September 16, 2021

El Paso County  
Planning and Community Development Department  
2880 International Circle, Suite 110  
Colorado Springs, CO 80910

Re: Letter of Intent for Colorado Springs Utilities Northeast Gravel Staging Area

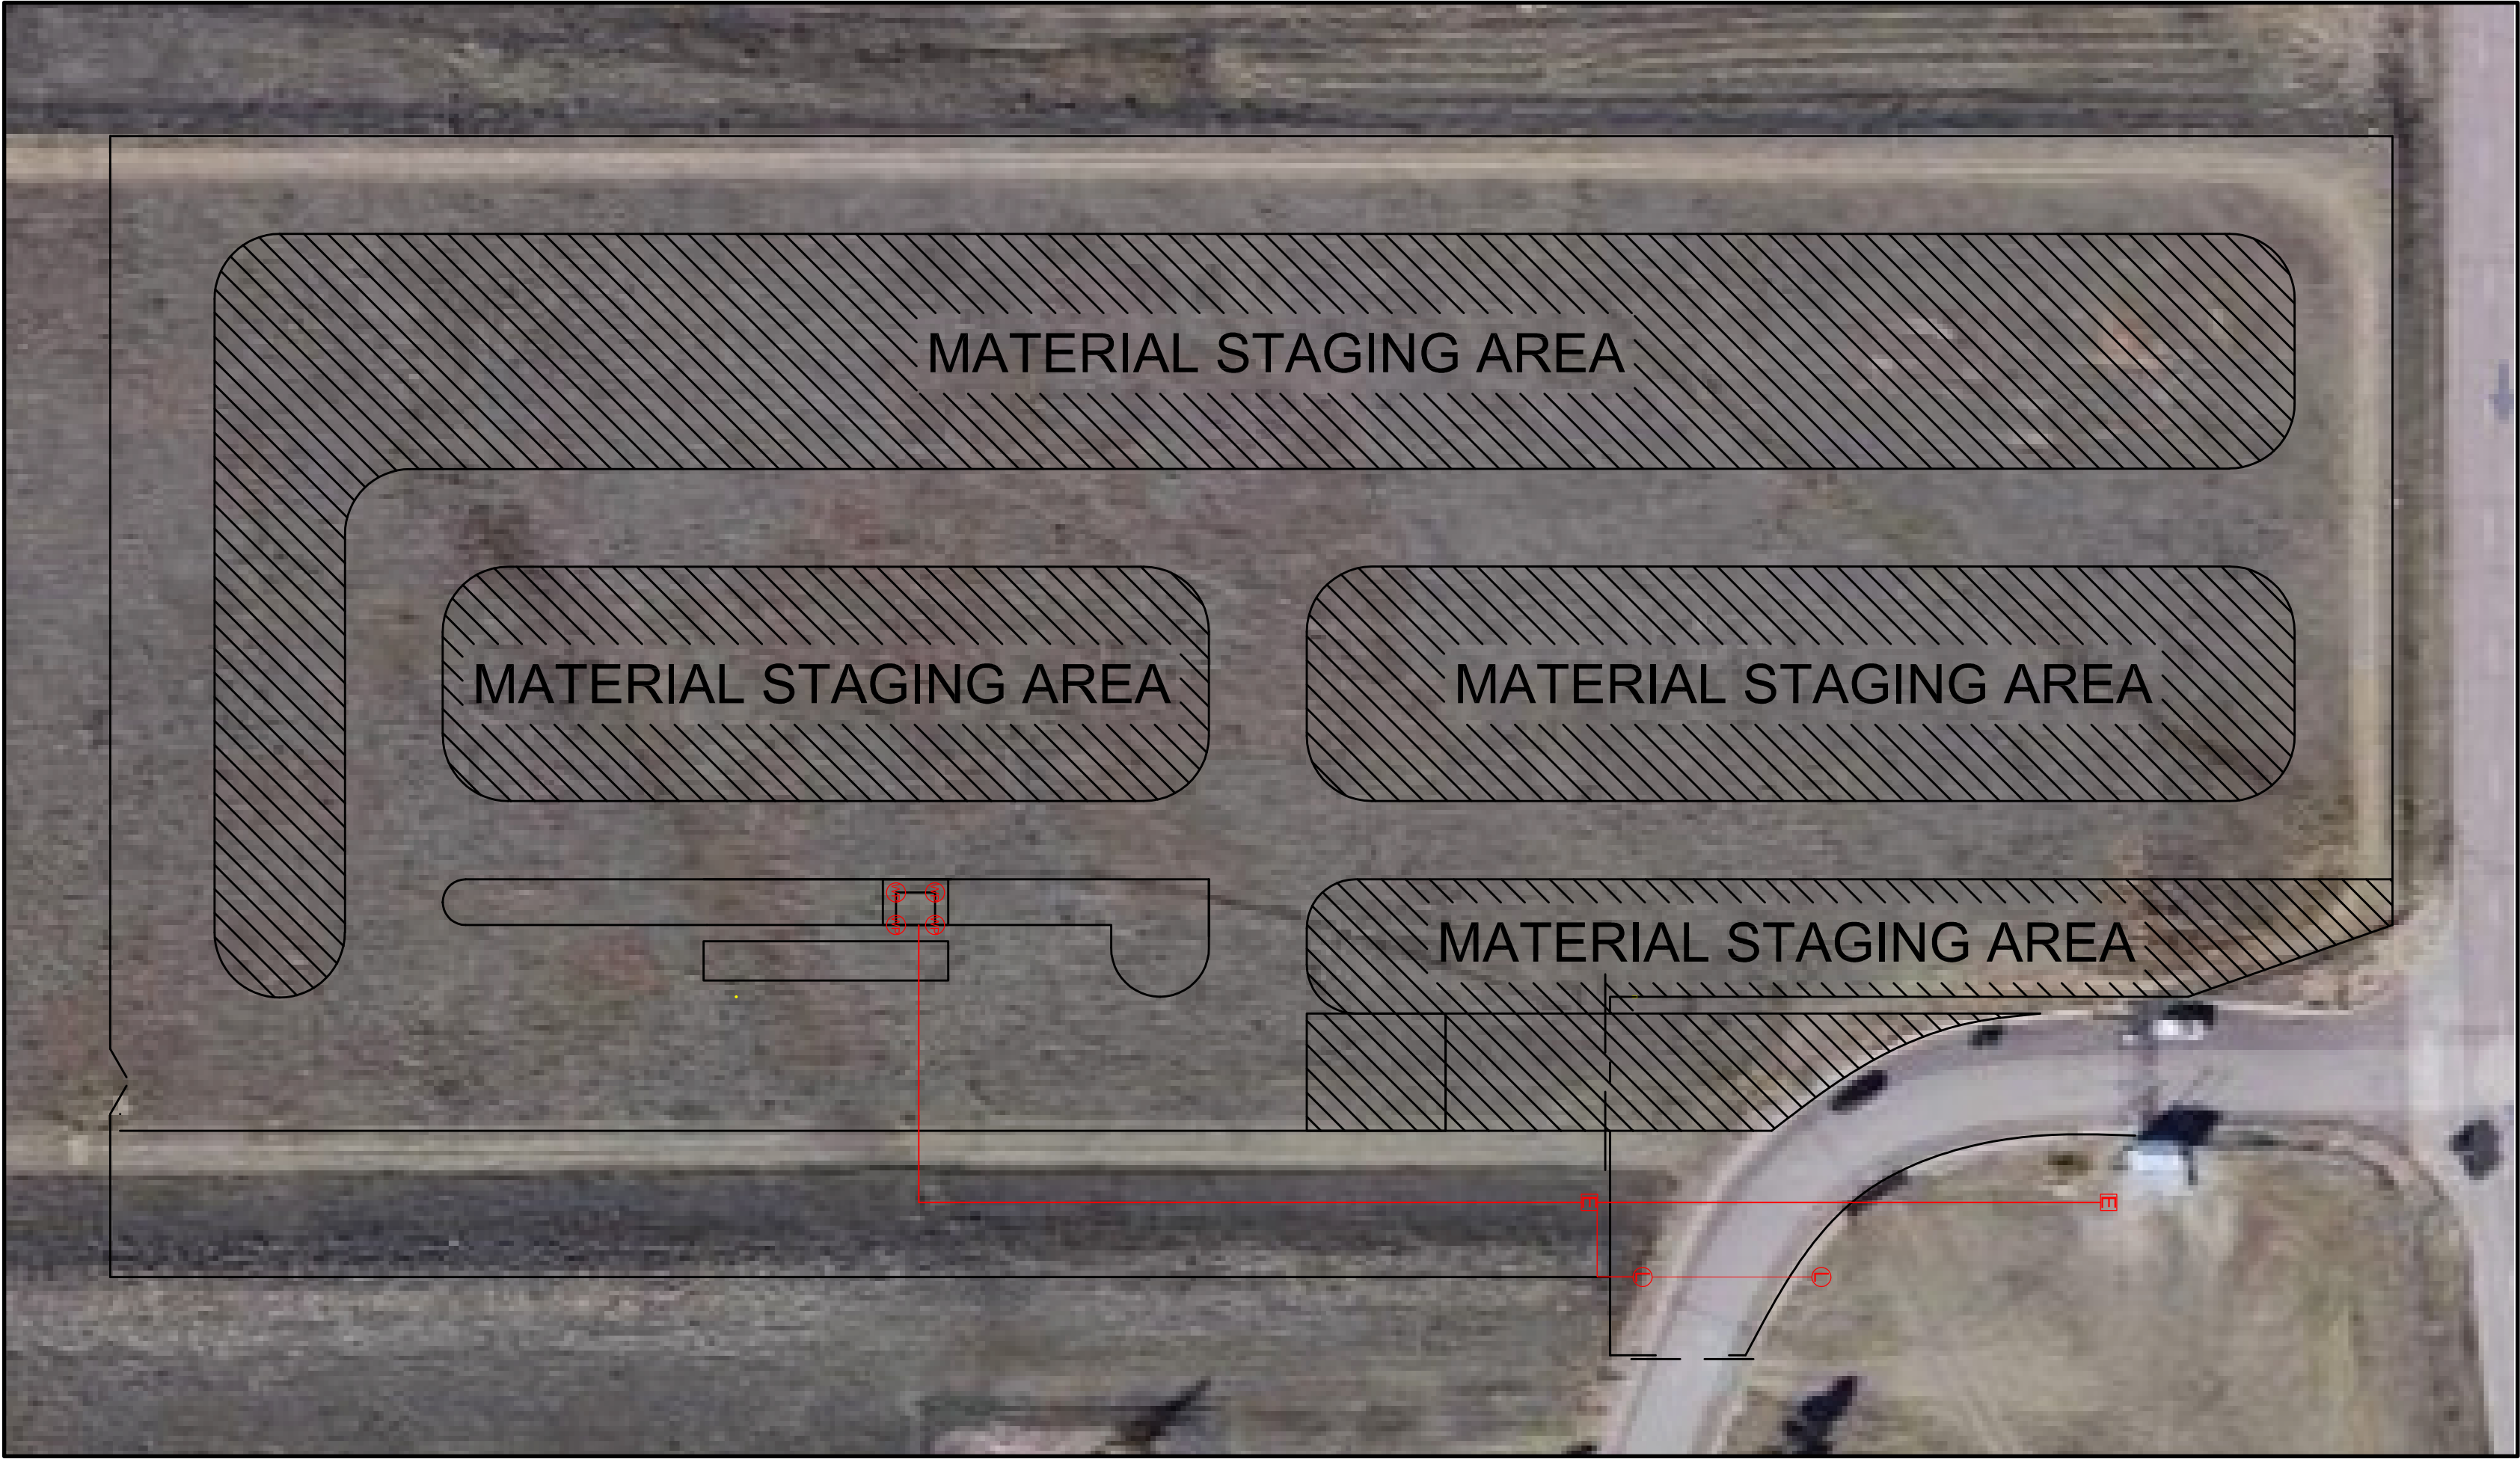
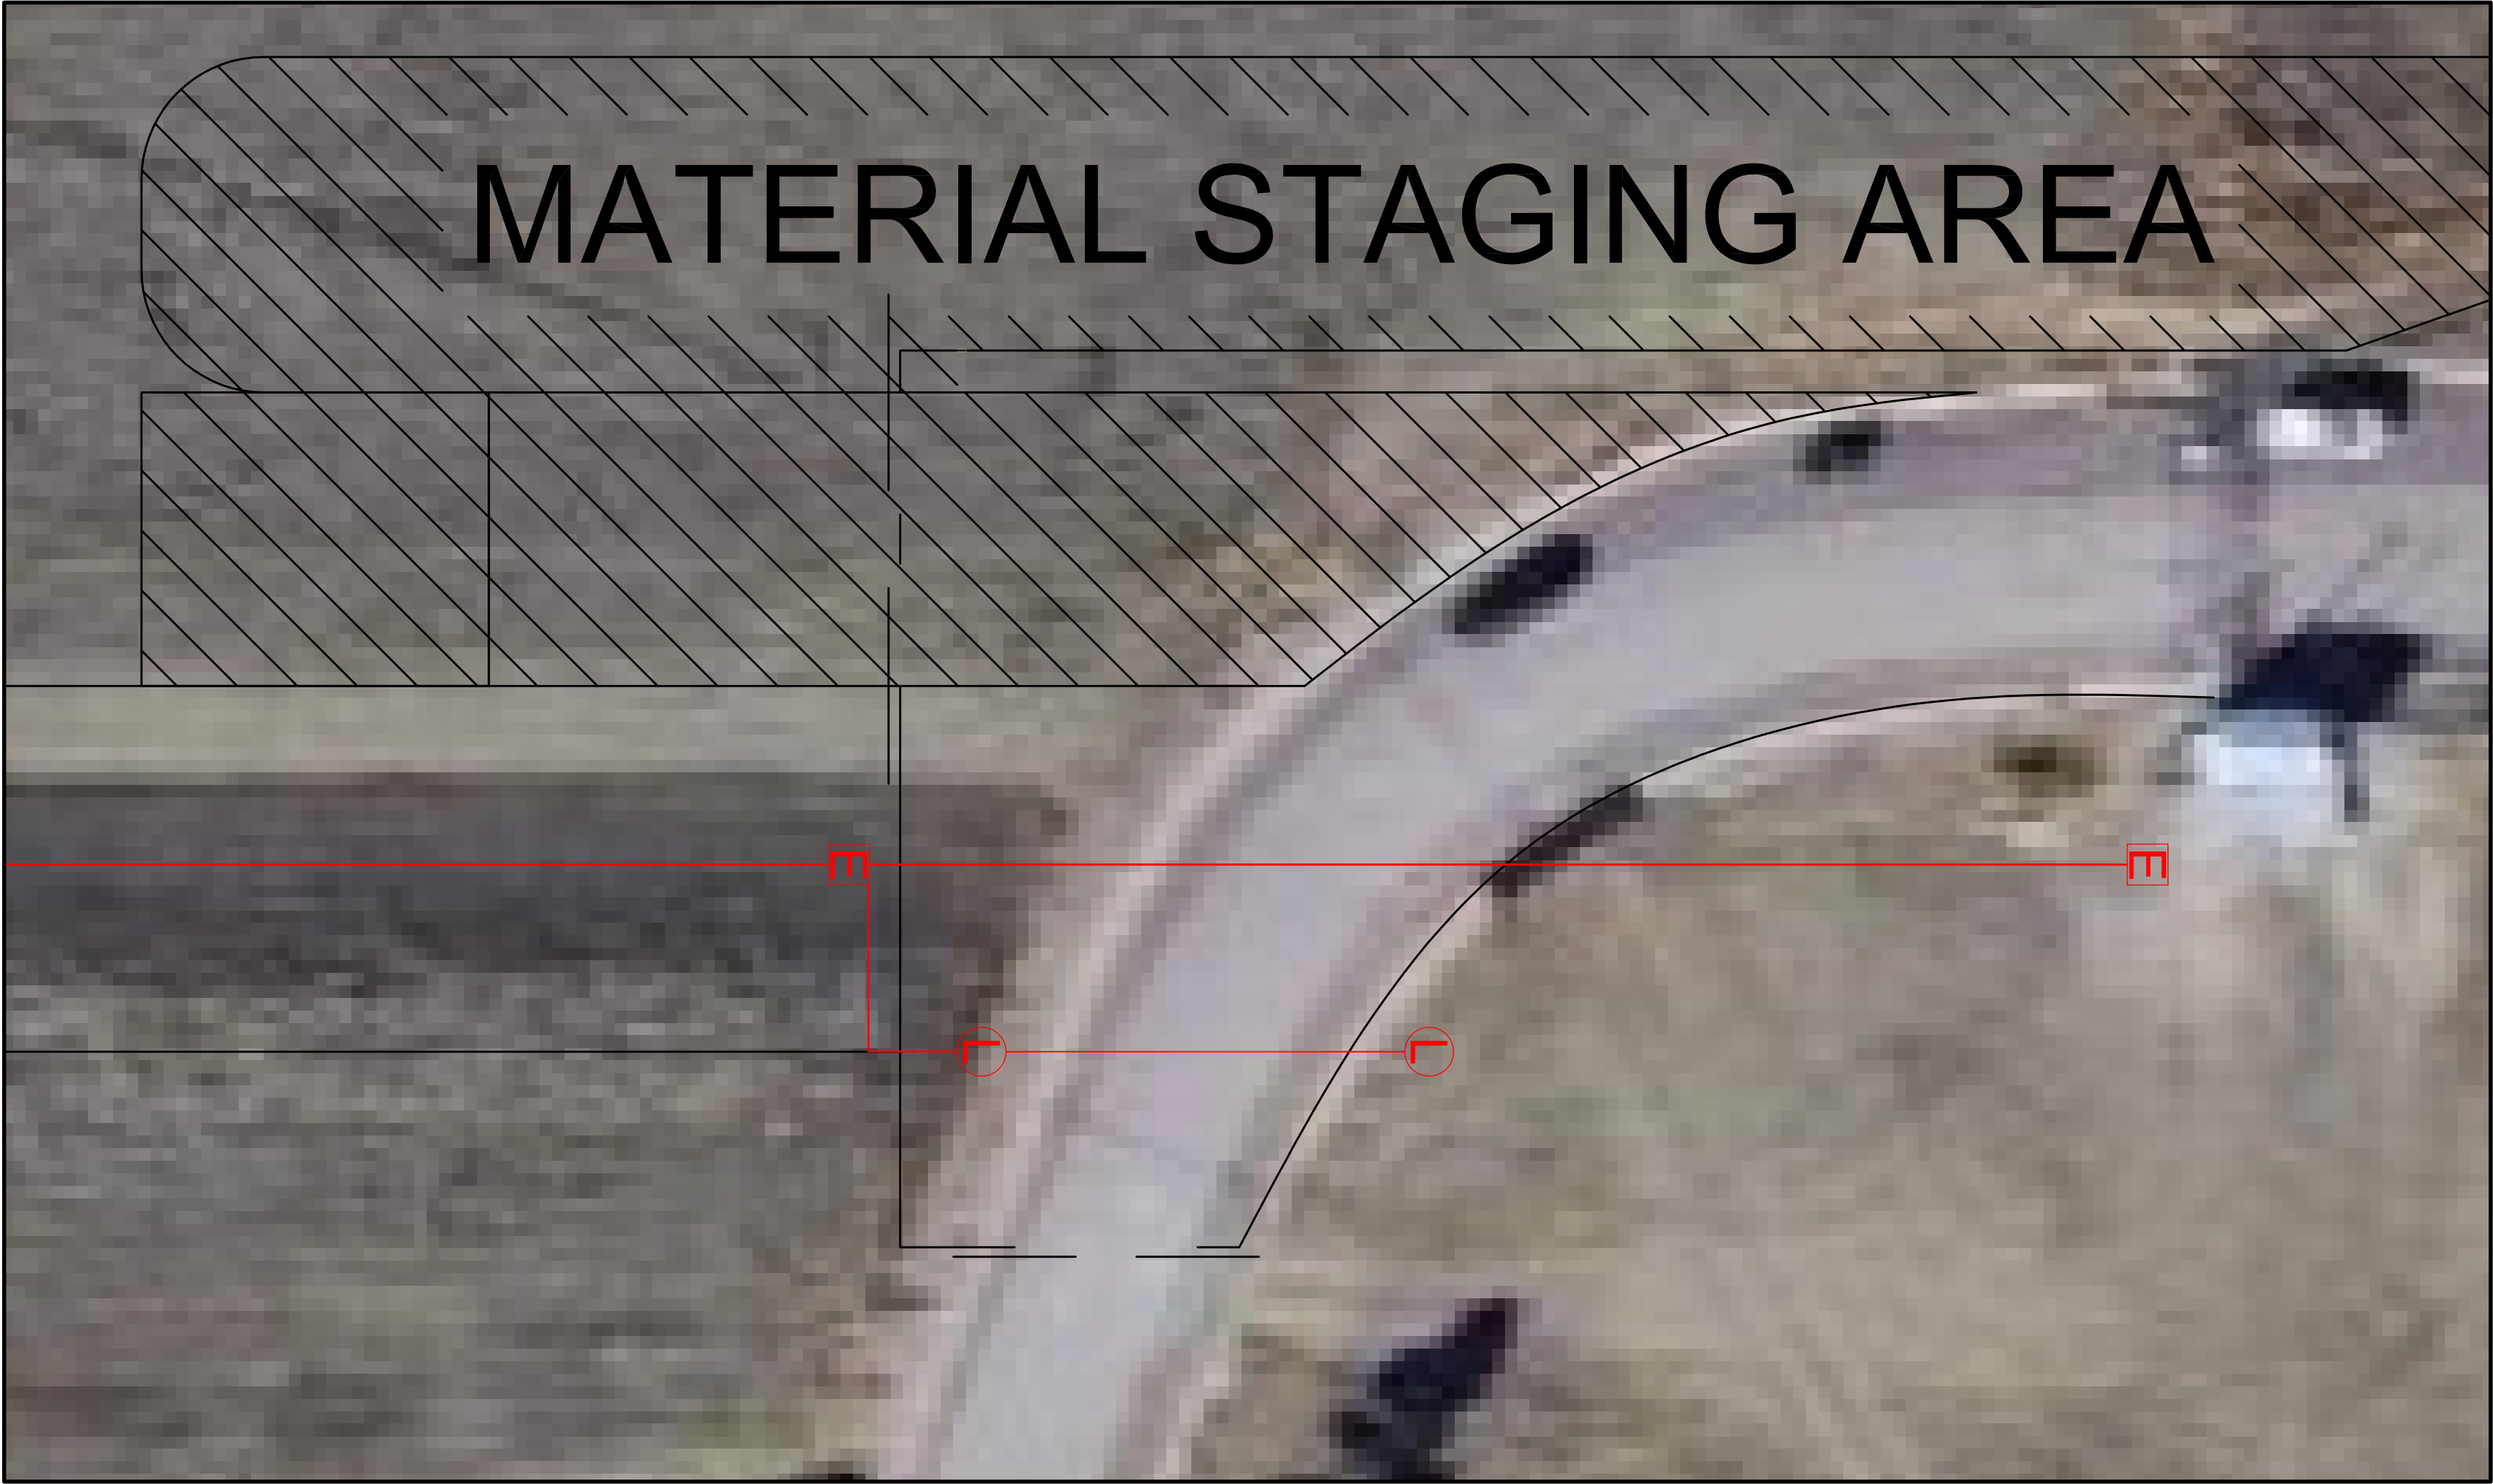
See comments on lighting plan and revise accordingly.
